Charlotte Department of Transportation

Memorandum

Date: August 25, 2008

Subject: Rezoning Petition 08-137: Located on the south side of Kenilworth Avenue between East Morehead Street and Harding Place

1301 E. MOREHEAD ST.
SCHEMATIC SITE PLAN

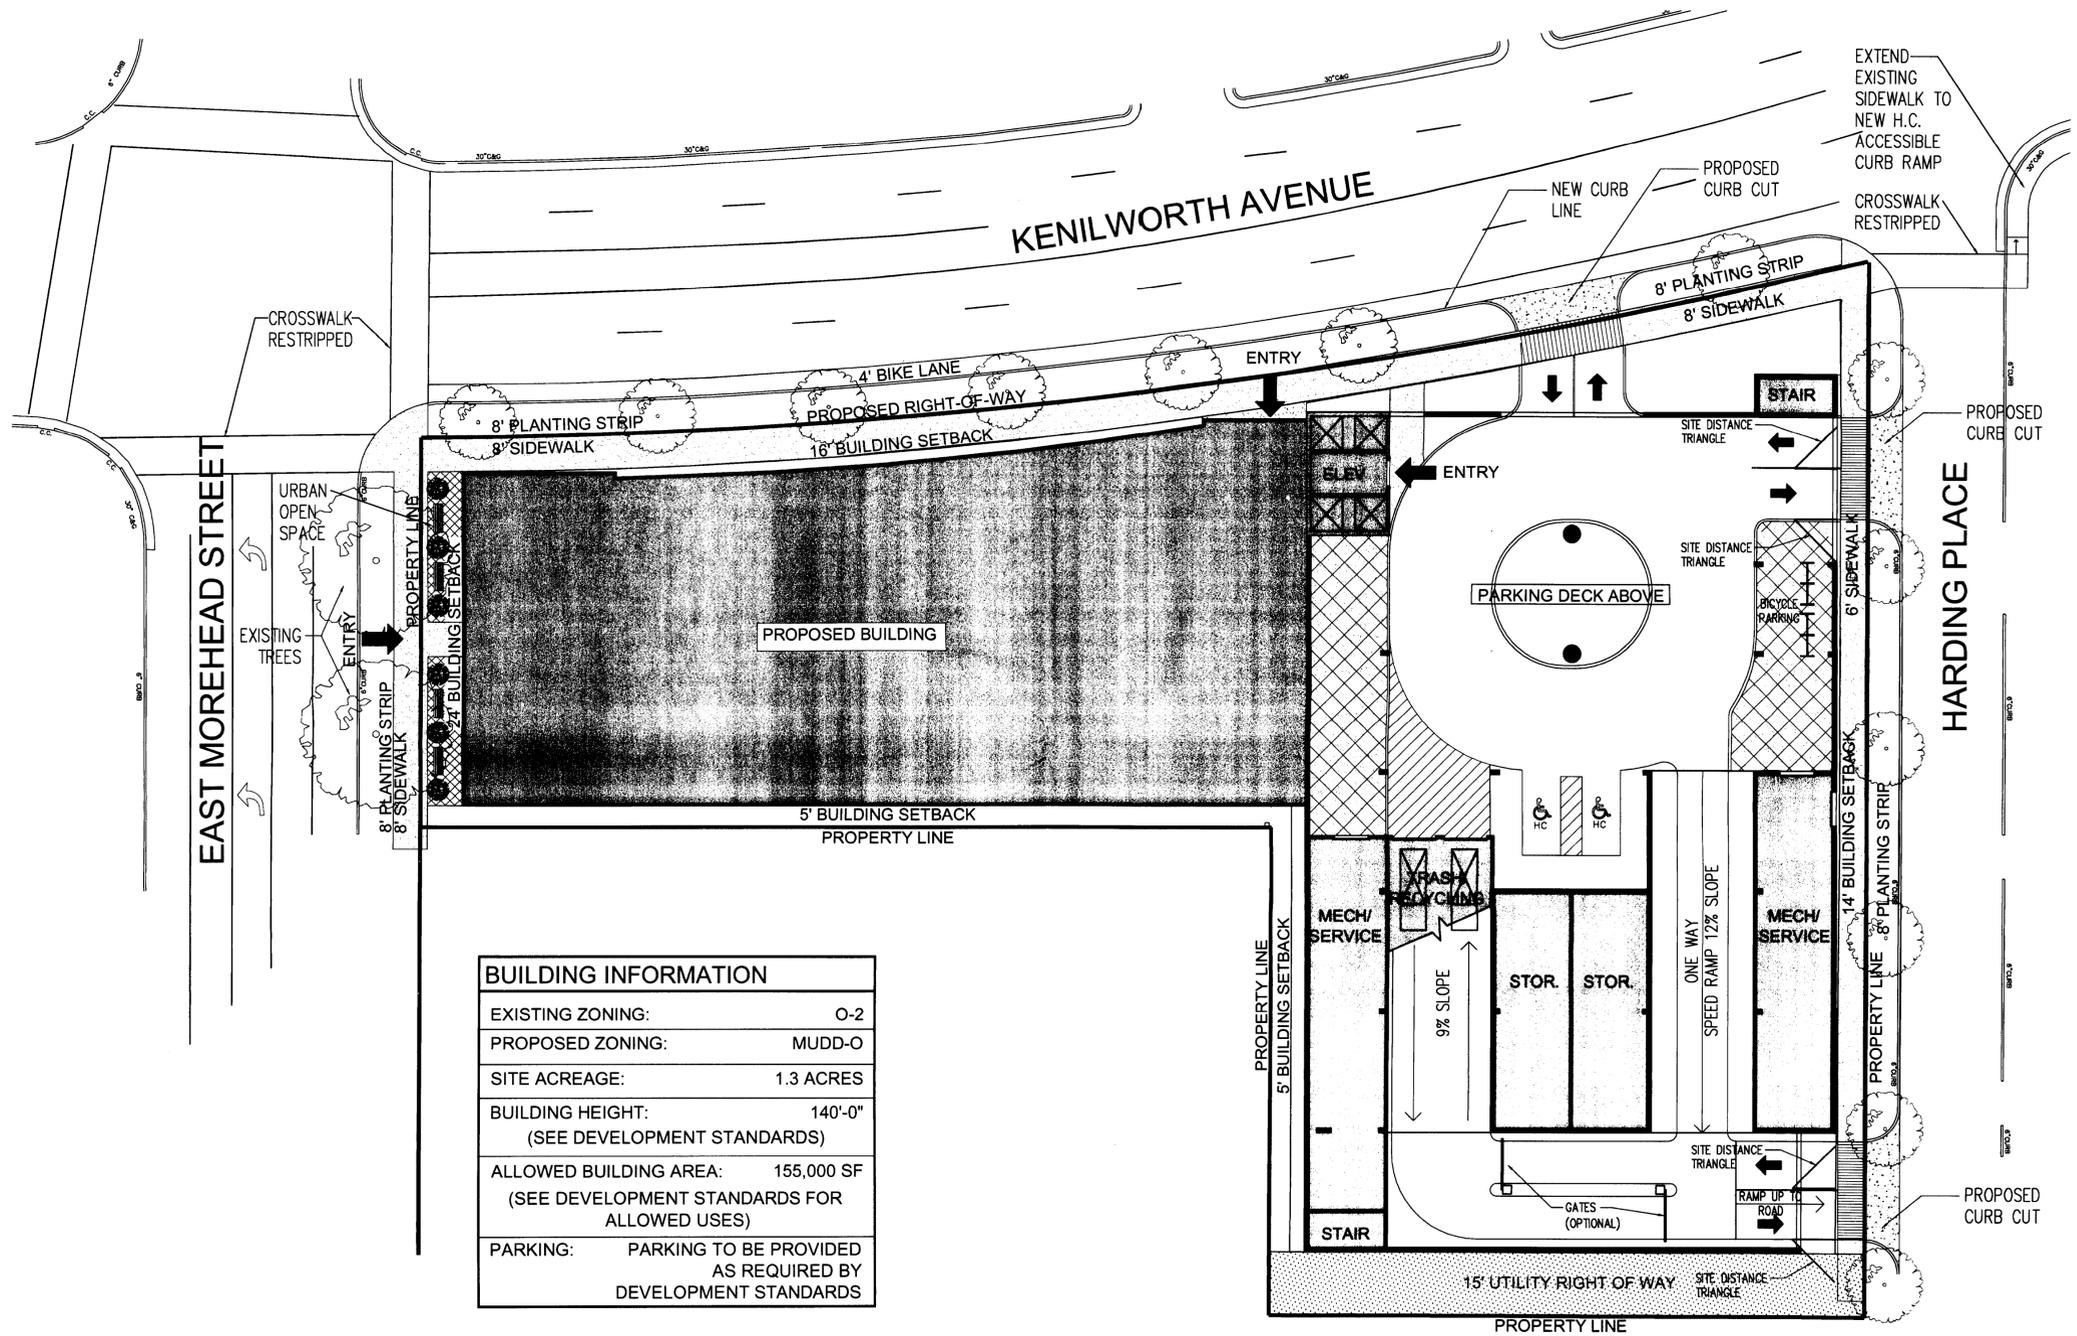
1. The mitigation package included the driveway onto Kenilworth Avenue to be signed as Right-In/Right-Out. This needs to be shown on the site plan.

1. We have concerns for the parking deck ramp design just beyond the gate controls. The short radius 90° turn is too small for 2-way traffic operation. Passenger vehicle turning templates need to be used for the design of this right-angled section of the ramp. Additionally the storage area walls present a blind corner at this location. Although these items will be reviewed during subsequent permitting processes, we recommend that these items be addressed at this time.

2. It appears from the configuration of the interior roundabout that the traffic entering the site from either driveway near the corner of Kenilworth Avenue and Harding Place may drive in the opposite direction of the one-way traffic to get to the parking garage ramp. Though this detailed review will be handled in subsequent review phases, we recommend this be reconfigured to consider traffic proceeding to the ramp.

3. As shown on the site plan, the accessible parking spaces do not include a van accessible space.
